Rampion 2 Wind Farm

Environmental Statement

Volume 4, Appendix 15.1: Sea scape, Landscape and Visual Im pact Assessment consultation responses

Document Reference: 6.4.15.1

Figure 15.59g  
 Viewpoint 40: Climping Beach

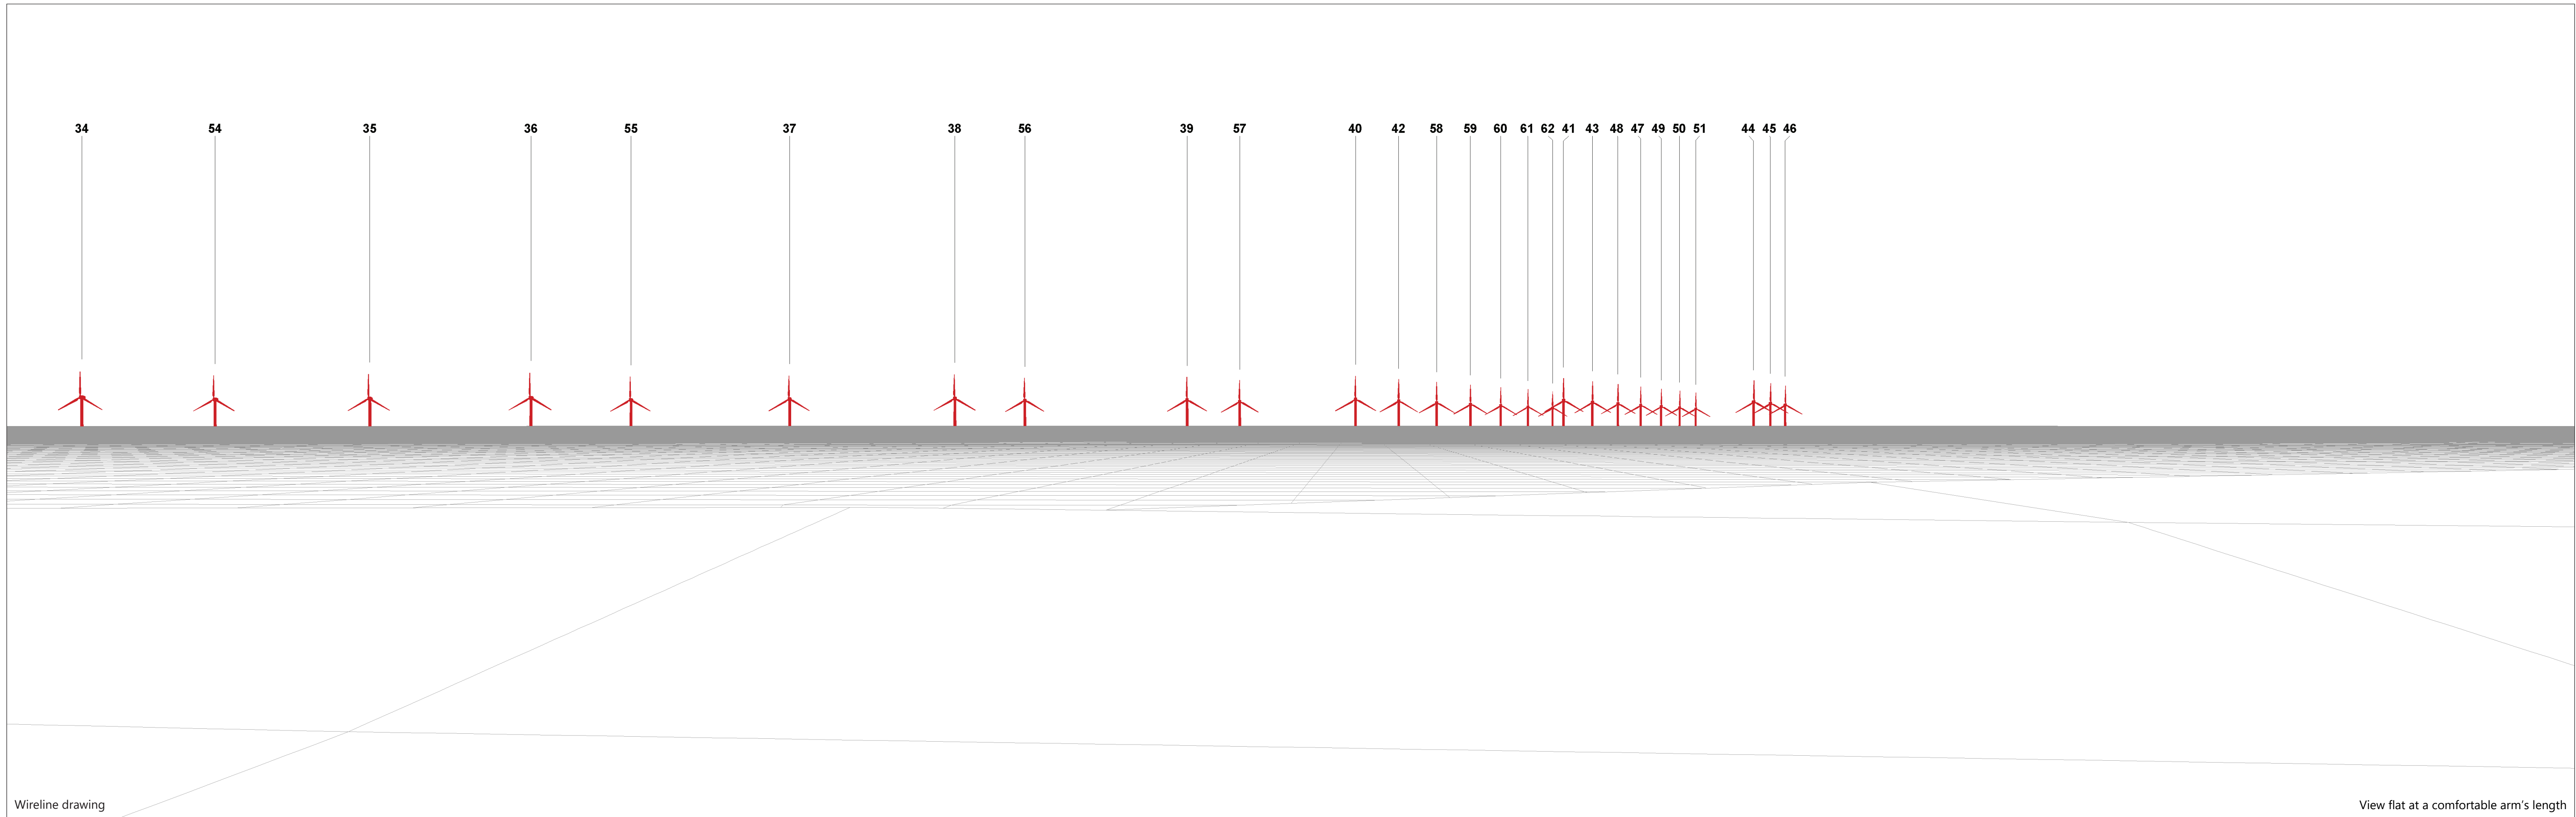
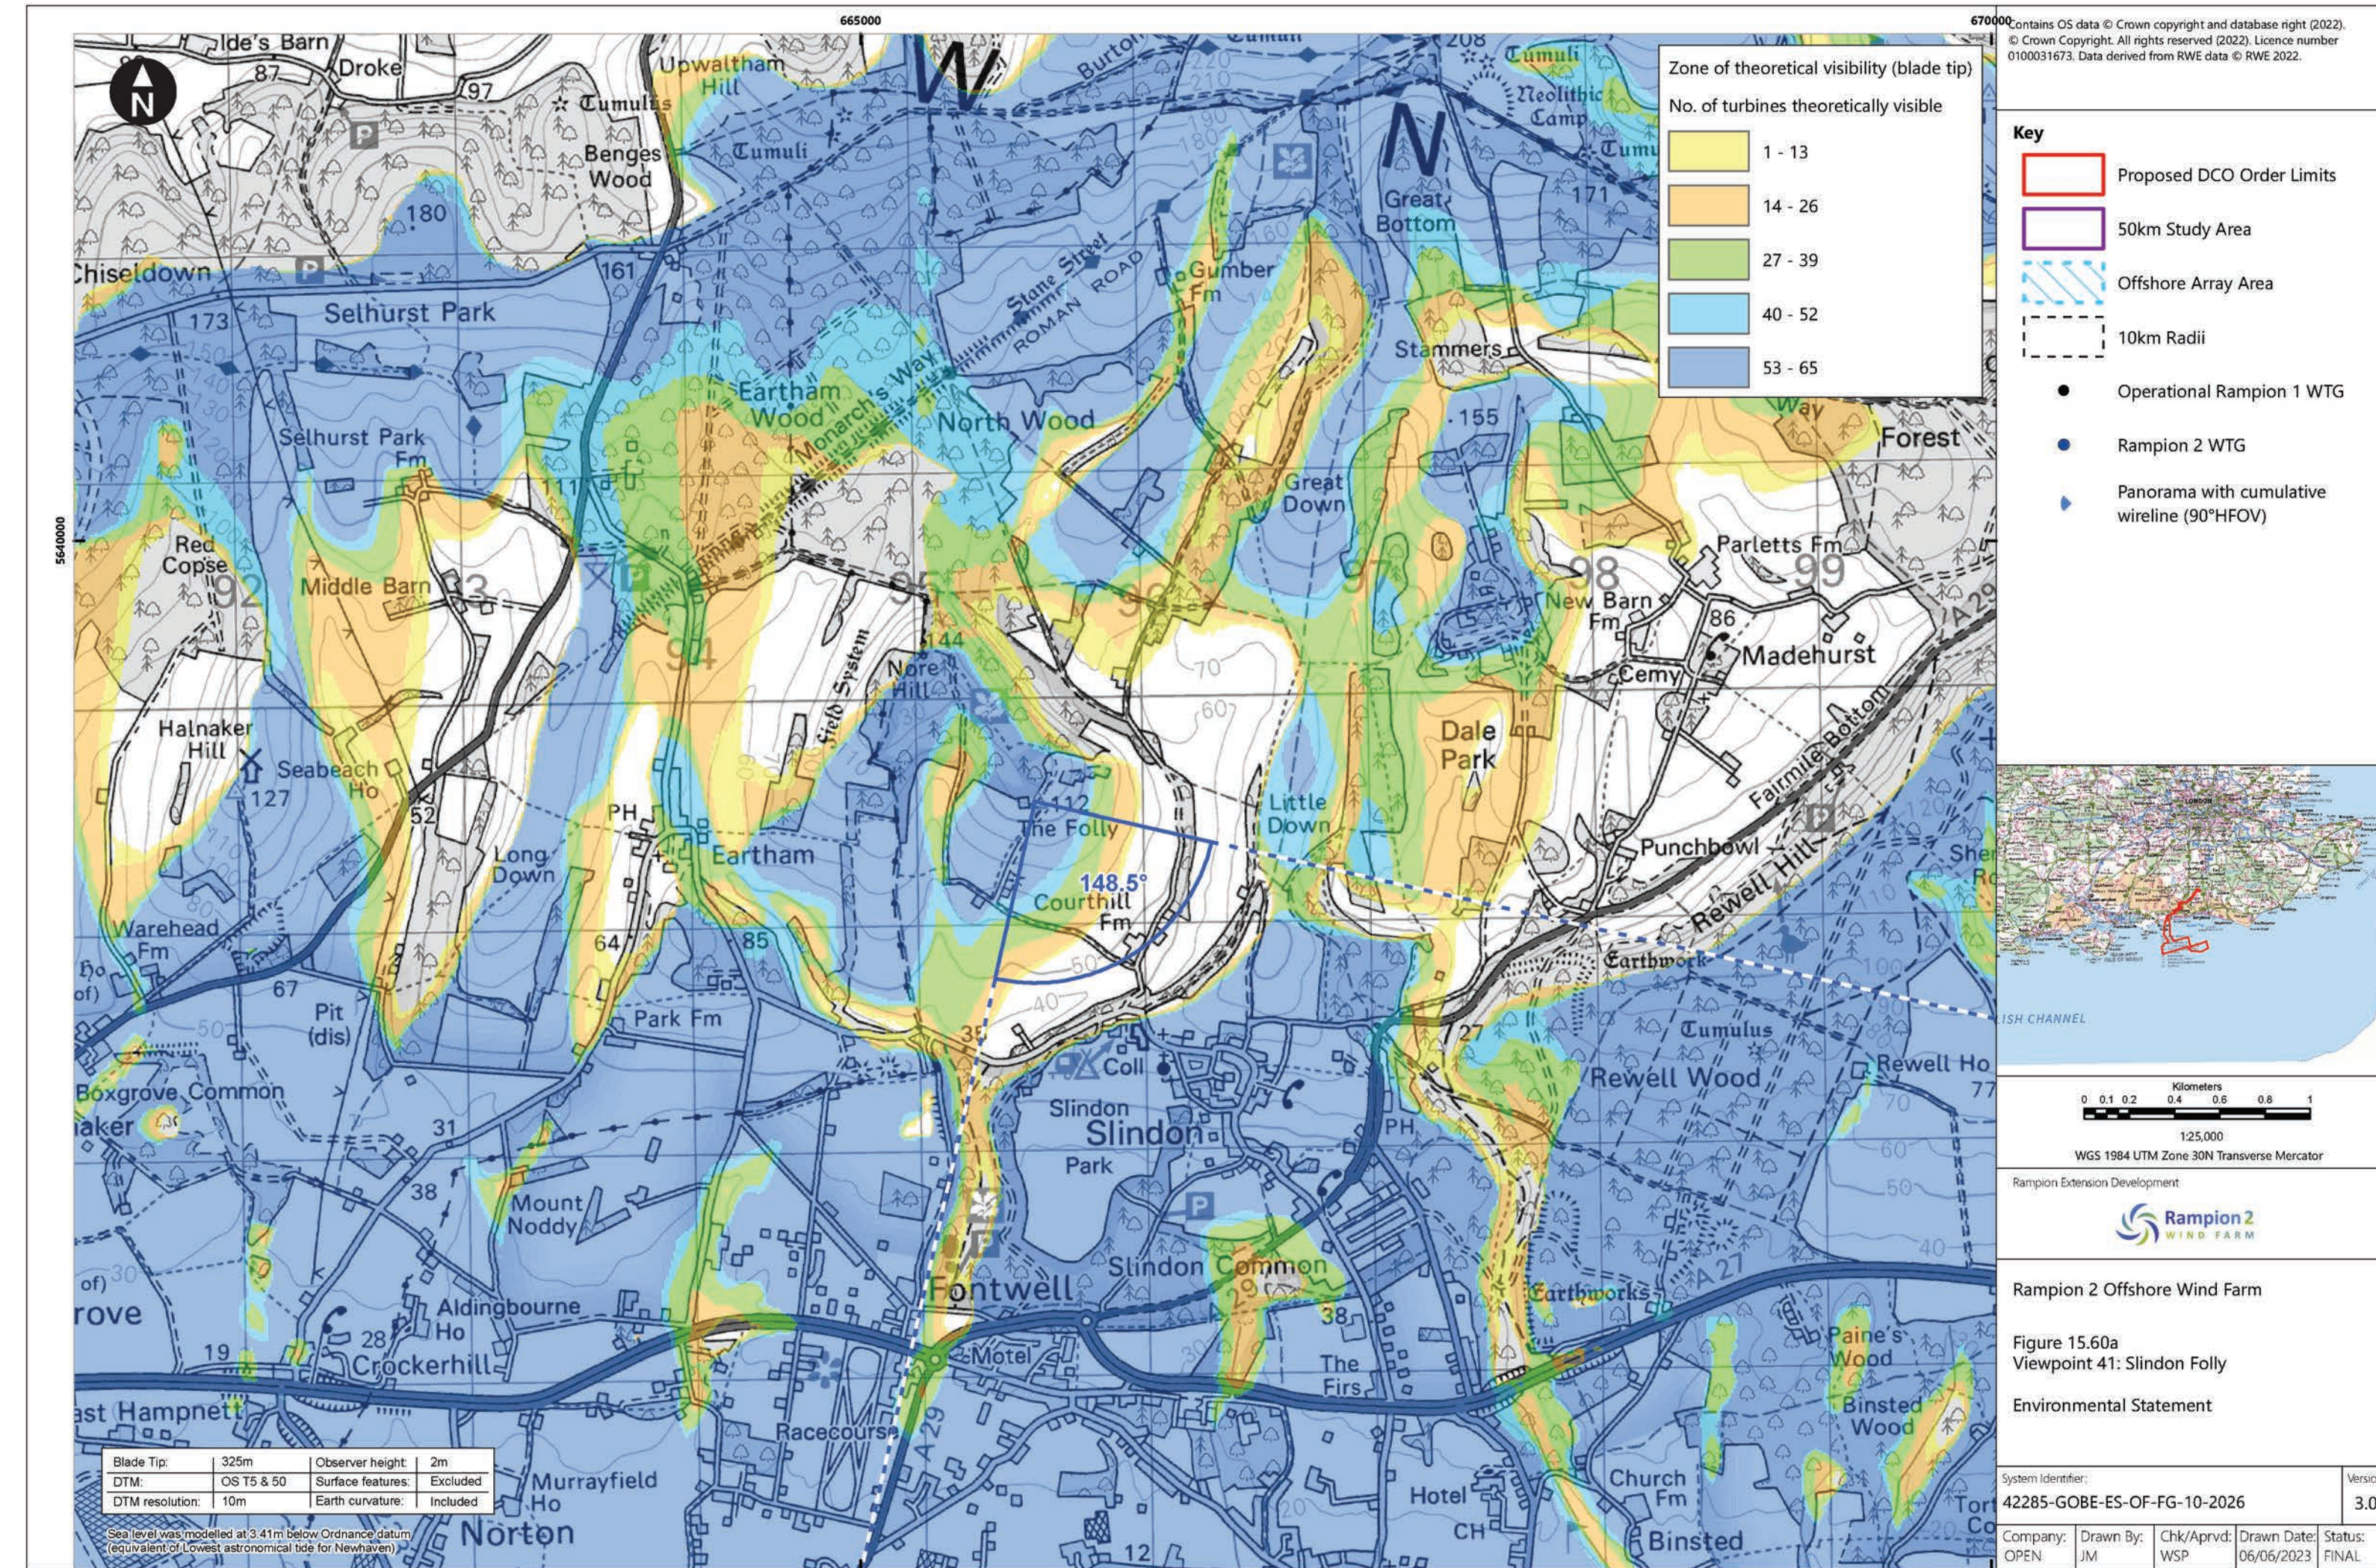
Consultee	Date / Document	Scoping Opinion Comment	How this is addressed in this ES
		<p>Rampion 2, but would suggest that a view from in Ventnor itself would represent a different user and have a different perspective of the proposals.</p> <p><u>Viewpoint No. 40 - Climping Beach</u>: The Trust is disappointed that this viewpoint has been excluded especially given that it was suggested by West Sussex County Council as well as the Trust. We would question the statement regarding detracting influences as this area of coastline is very undeveloped and “wild”, primarily as a result of the National Trust Covenant which has been in place since 1973. The users of this piece of coastline are very different from those at viewpoint 11 and the landscape within which people will experience the potential windfarm development is very contrasting with viewpoint 11 being urban and developed where as Climping Street and the beach are natural and dynamic as a result of little coastal protection. The Trust would ask for reconsideration of the exclusion of this viewpoint from the SLVIA, especially as it is the favoured location for coming onshore.</p> <p><u>Viewpoint No. 55 - Beeding Hill</u>: The Trust owns and manages Beeding Hill</p> <p><u>Viewpoint No. 57 - Telscomb Tye</u>: The Trust has covenanted land at Telscomb Tye.</p> <p><u>Viewpoint No. 62 - Beacon Hill</u>: It would appear that this viewpoint is likely to be on National Trust land and also open access land.</p>	<p>viewpoint on Bonchurch Down, to the east of the radar station.</p> <p><u>Viewpoint 40: Climping Beach (Figure 15-59, Volume 3 the ES (Document Reference 6.3.15))</u>; The effects of the onshore infrastructure from Climping Beach are assessed in Appendix 15.4: Visual assessment, Volume 2.</p> <p><u>Viewpoint 55</u> noted.</p> <p><u>Viewpoint 57</u> noted.</p> <p><u>Viewpoint 62</u> noted.</p>

Figure 15.61c  
 Viewpoint 43: Gilkicker Point

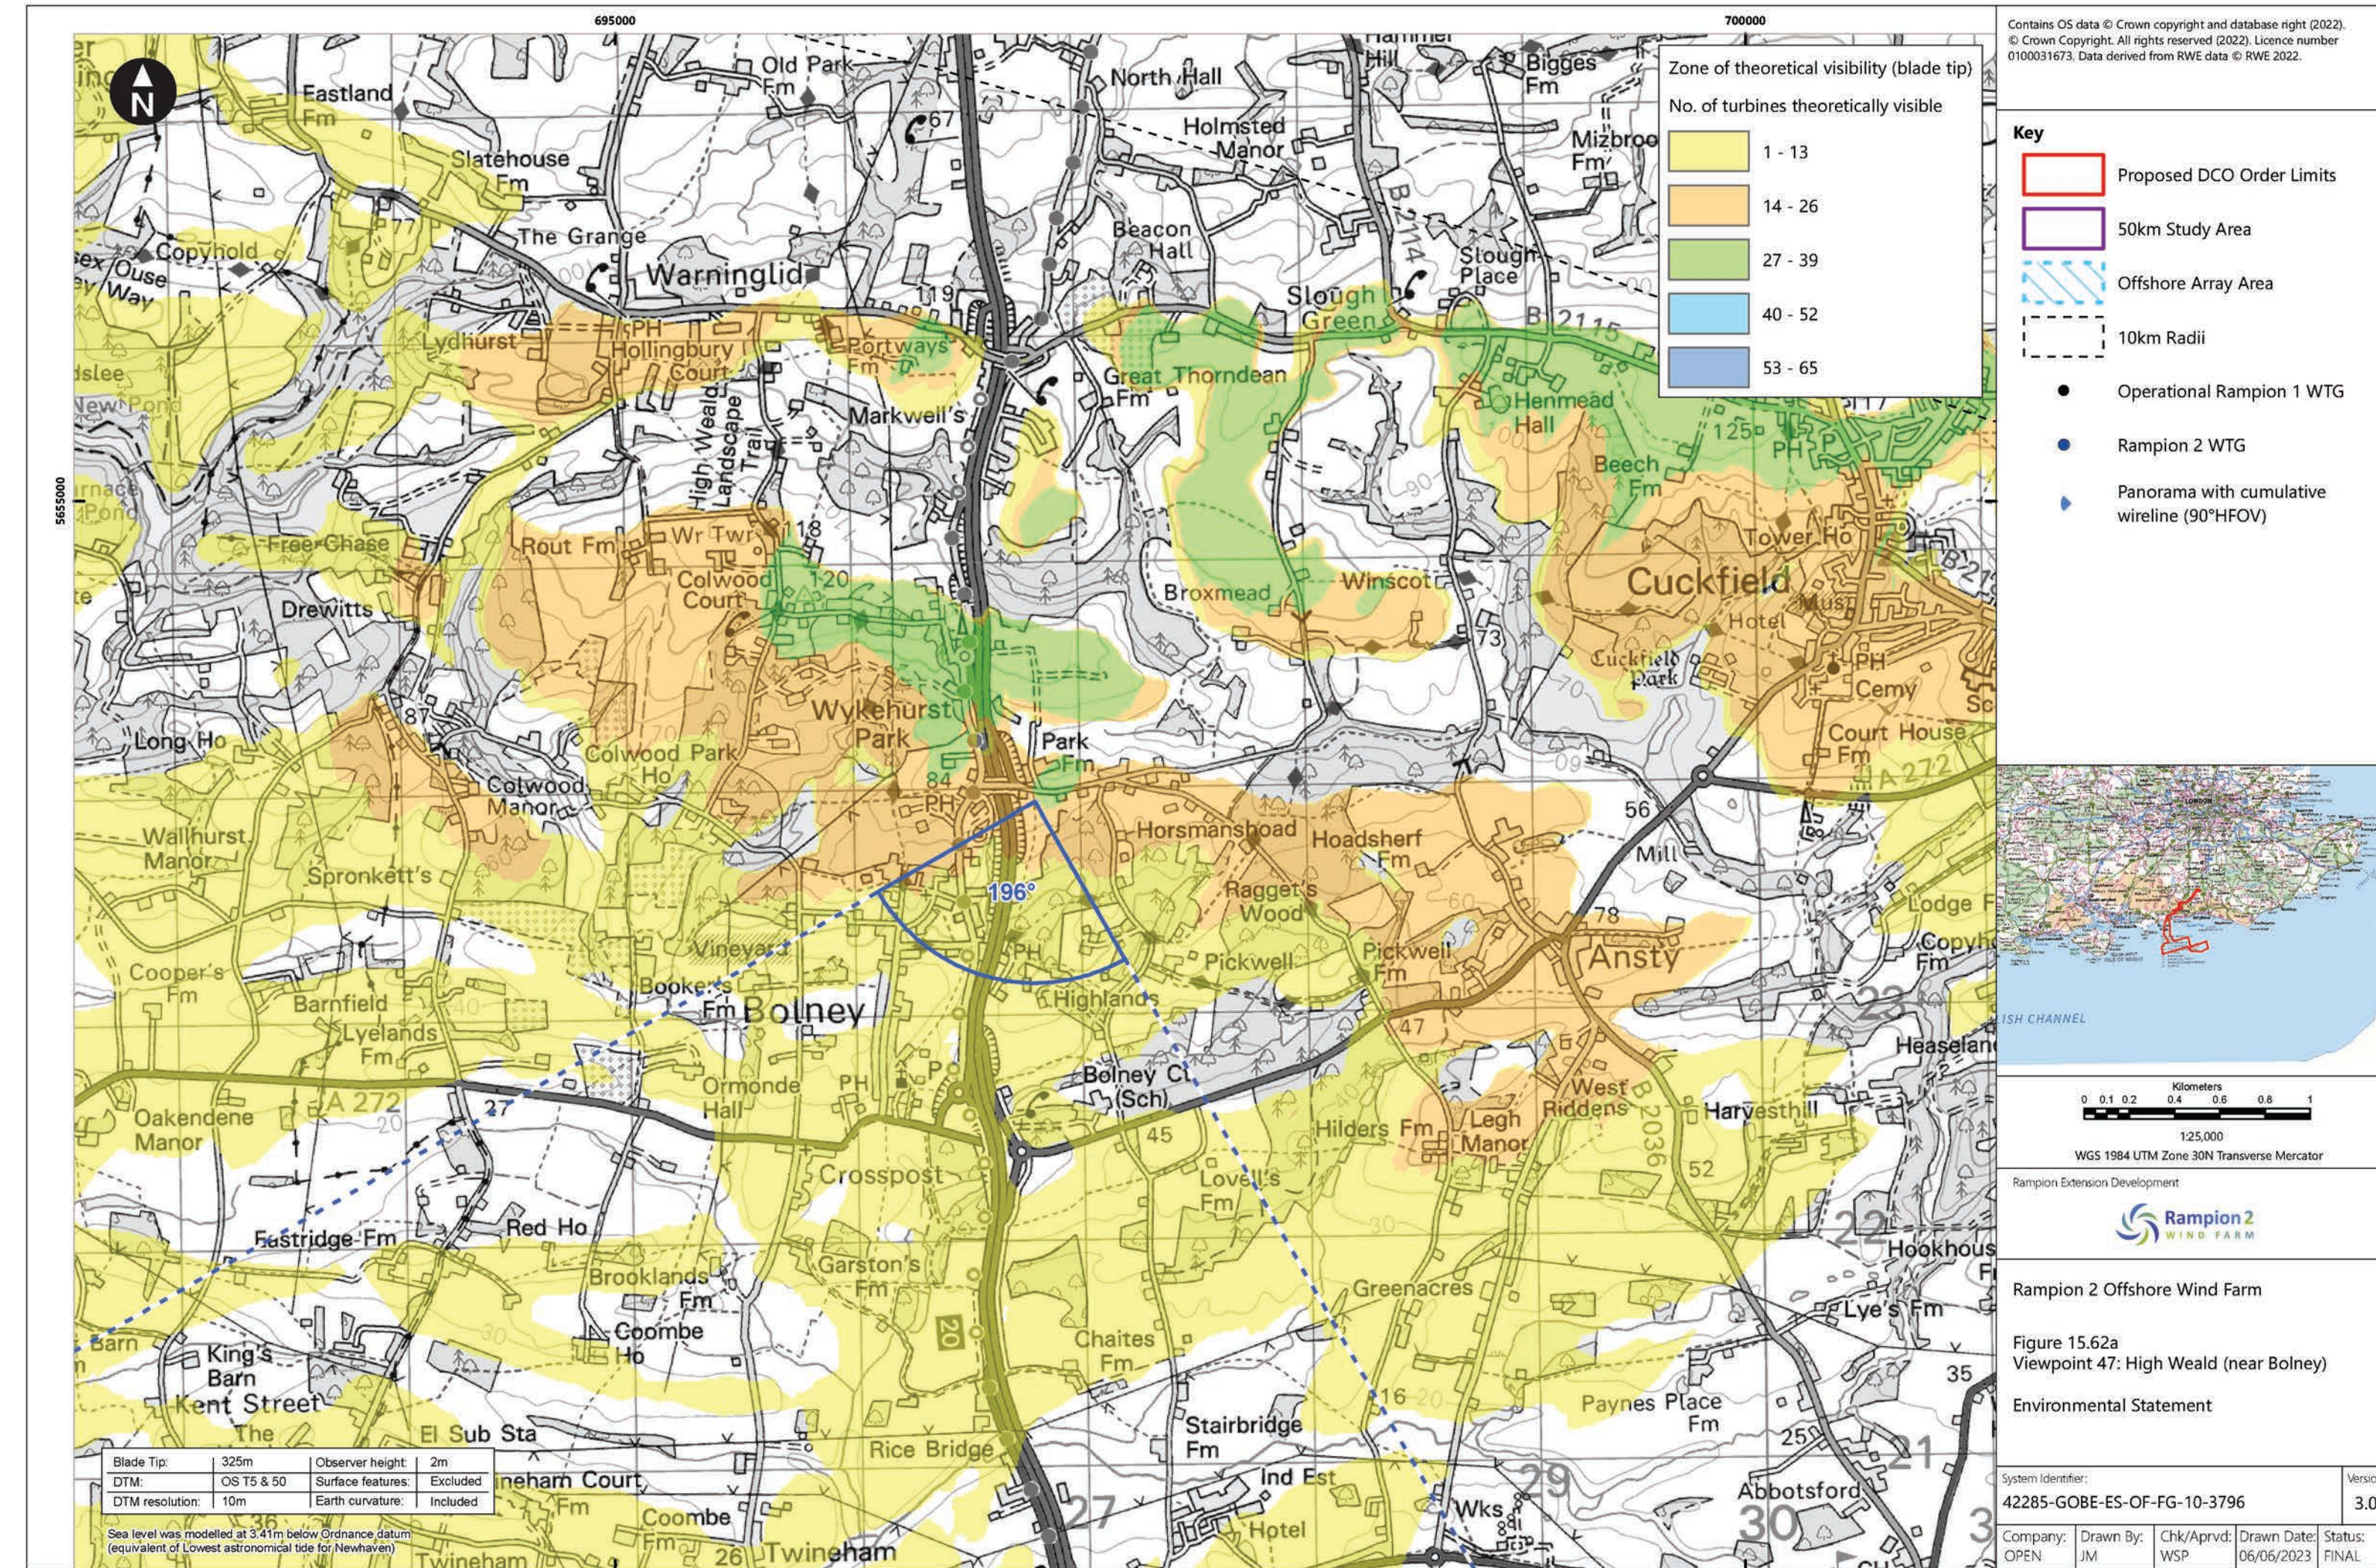
Consultee	Date / Document	Scoping Opinion Comment	How this is addressed in this ES
	November 2020		
Hampshire County Council	Early engagement 12/08/2020	<p>Here are the additional viewpoints we would like you to consider- obviously without going to the extent of checking in mapping some may need refinement in terms of exact location:</p> <ul style="list-style-type: none"> • within Hampshire but outside the South Downs National Park- two views from the shore, to illustrate what will be sequential views seen from sections of the our coastline : <ul style="list-style-type: none"> a) Lepe/Calshot foreshore b) Gilkicker Point • within Hampshire, inside the South Downs National Park- where we have the benefit of the Park's published Viewshed study which identifies 'Representative' and 'Landmark' viewpoints, each of which is accompanied by a ZTV- three additional viewpoints e) VP5/ L2 Old Winchester Hill, f) VP8 Butser Hill and g) L39 Catherington Windmill 	Viewpoints selected for the SLVIA are presented in Chapter 15: Seascape, landscape and visual impact assessment, Volume 2 of the ES (Document Reference 6.2.15), Section 15.6 and Table 15-14 and assessed in full in Appendix 15.4: Viewpoint assessment, Volume 4 of the ES (Document Reference 6.4.15.4), which include views from Gilkicker Point (Viewpoint 43) and Butser Hill (Viewpoint 31).
